RE: **ABQ Biopark Elephant Exhibit**  
**903 10<sup>th</sup> St SW**  
**Engineer's Stamp Date 6/13/17**  
**Hydrology File: K13D034B**

**RE: ABQ Bio-park Elephant Barn (K13D034B)**

Attached with this letter is a revised Grading & Drainage Plan for the proposed Elephant Barn project at the ABQ Biopark. Revisions were made based on your review comments dated June 7, 2017. The following items correspond to your original numbered comments.

CG-101

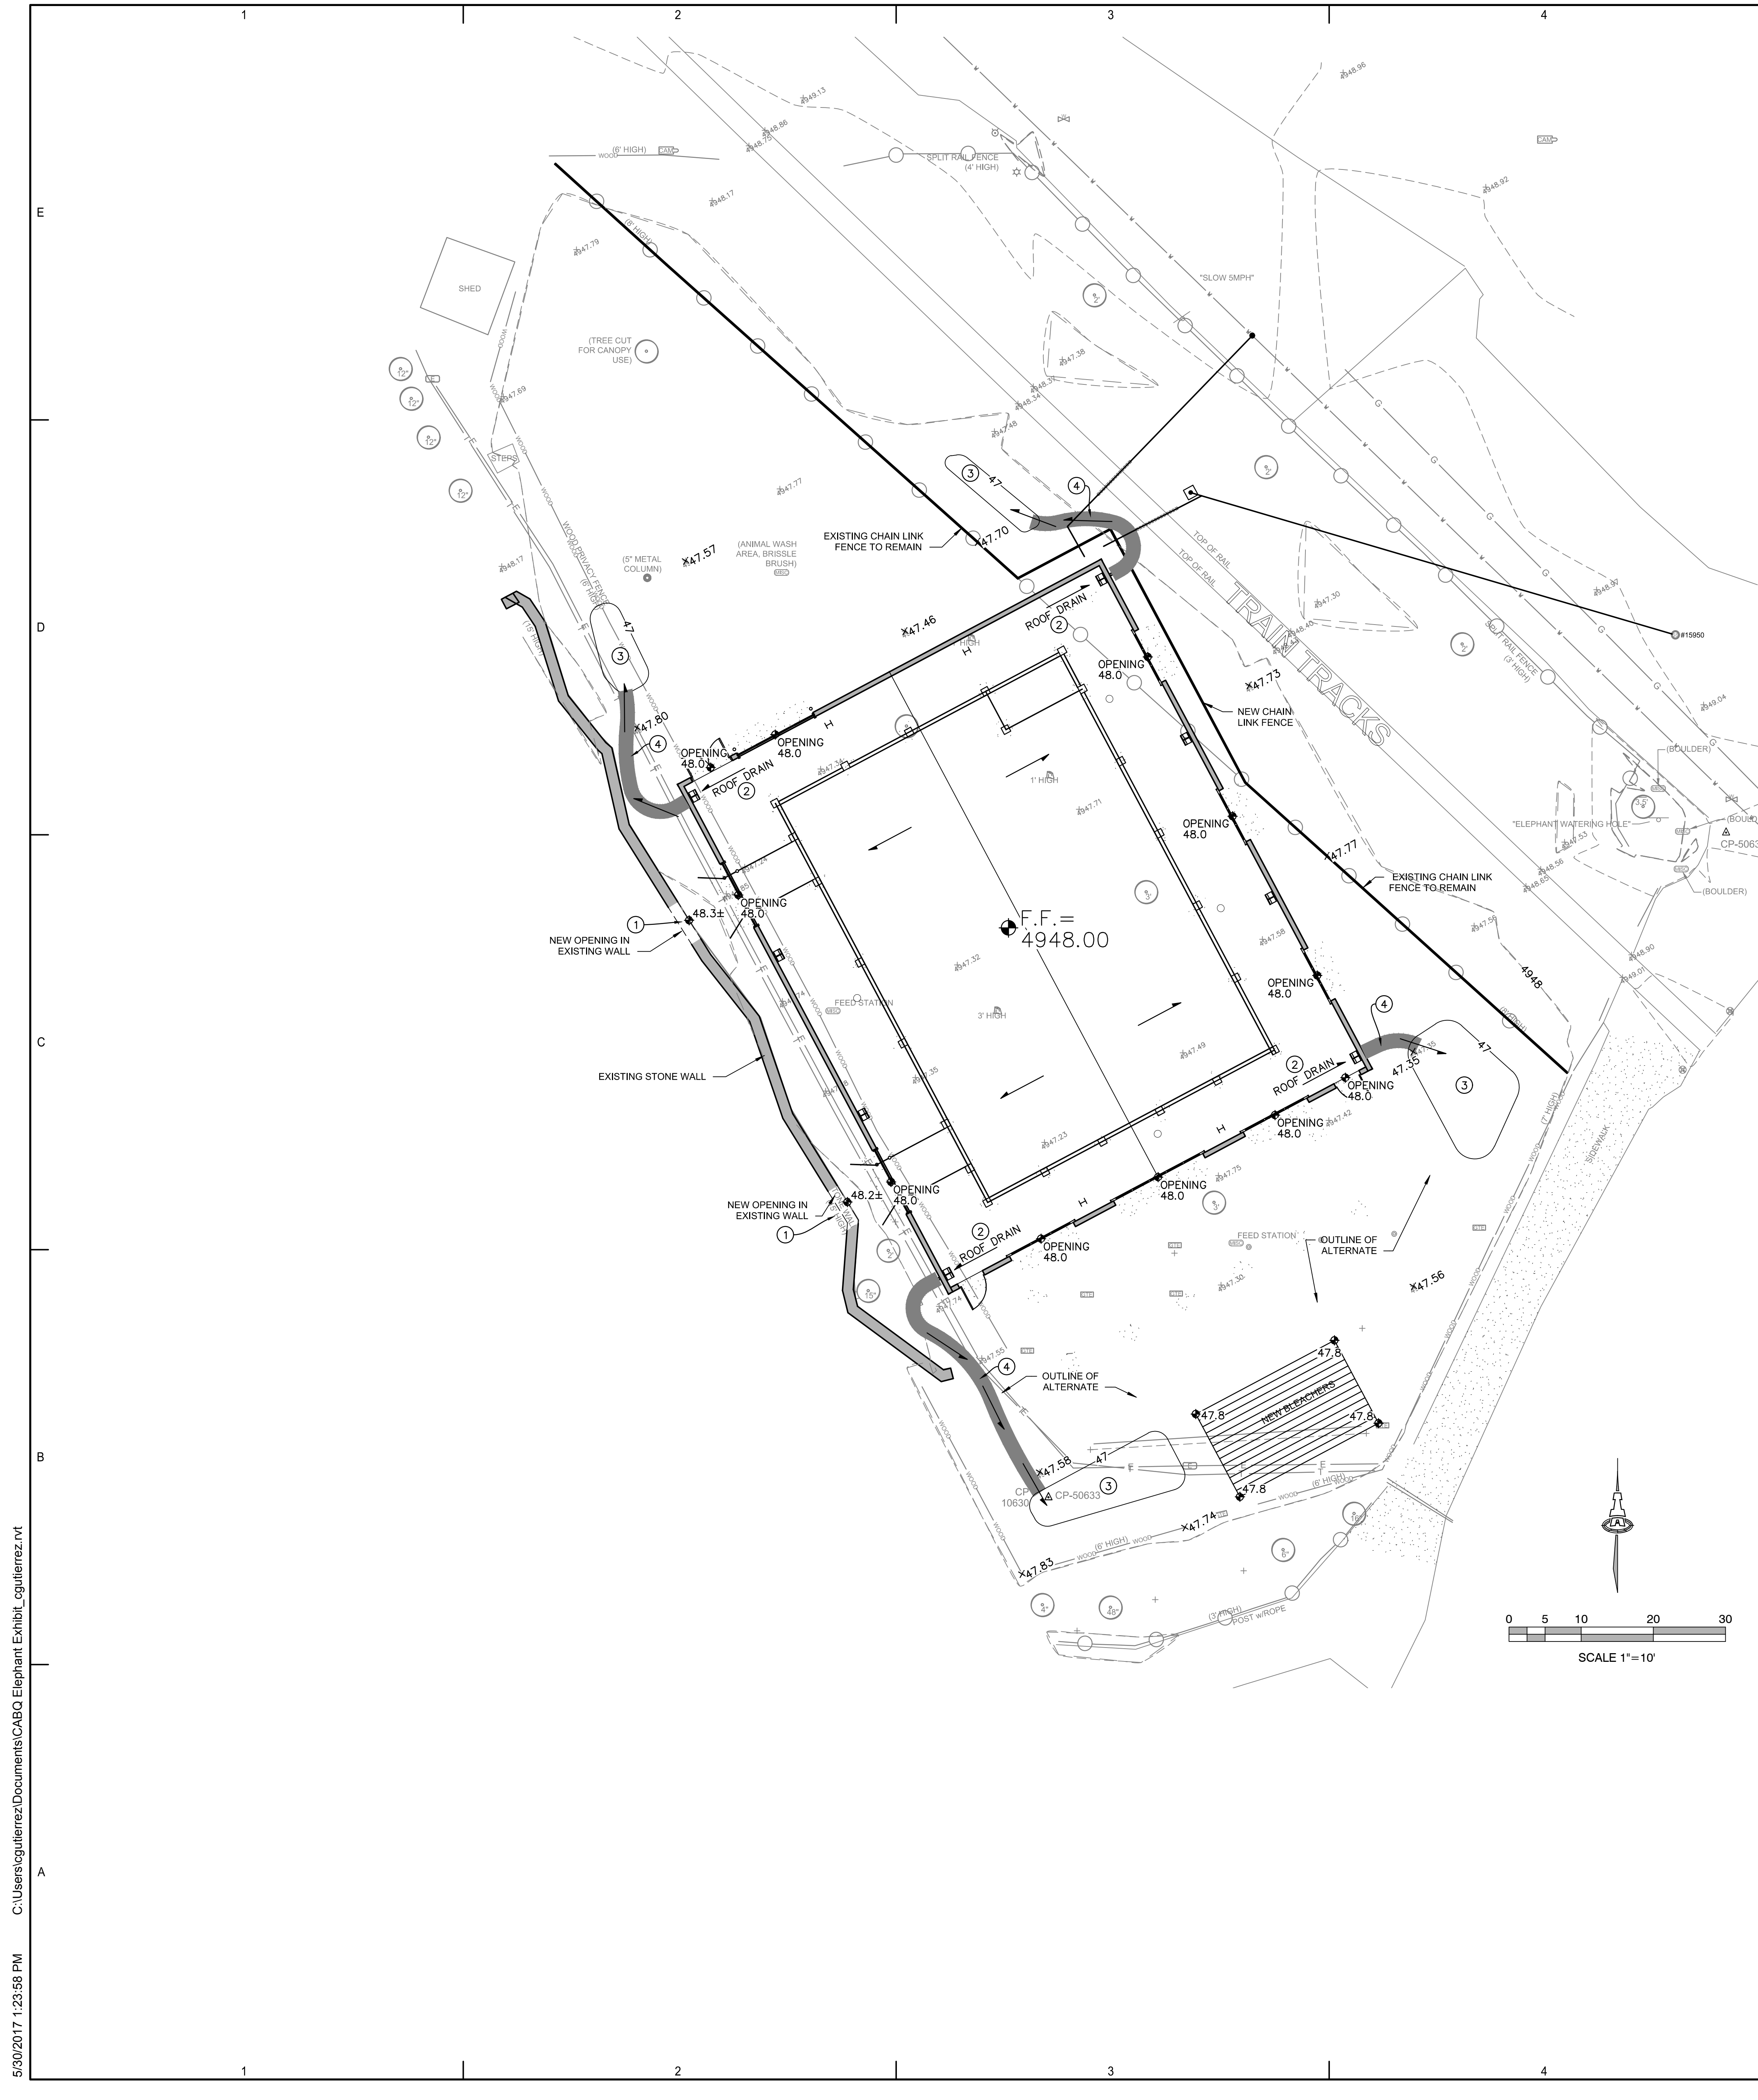
1. A supplemental information packet included with this submittal provides basin analysis and confirmation of the 100-year 10-day storm volume.
2. The maximum water surface elevation of 4948.5 has been noted on the plan.

3. The finished floor of the new elephant barn has been set to 4949.0 which is 0.5' above the MWSE. The reasons for this are:
  - a. The available volume at elevation 4949.0 is 28,225 cf which is 17,962 cf more than the 100-year 10-day volume of 10,263 requires.

- b. The barn is an open air enclosure with crusher fines & sand floor.
  - c. The access doors on the west side transition to existing over a short distance (7'±) which limits the FF elevation.

- d. Based on emails exchanged with the project architect, Robert Brumfield with Van H. Gilbert Architect, the building cannot be relocated because of potential interference with the existing train tracks. He has discussed this with his project contacts at the biopark.
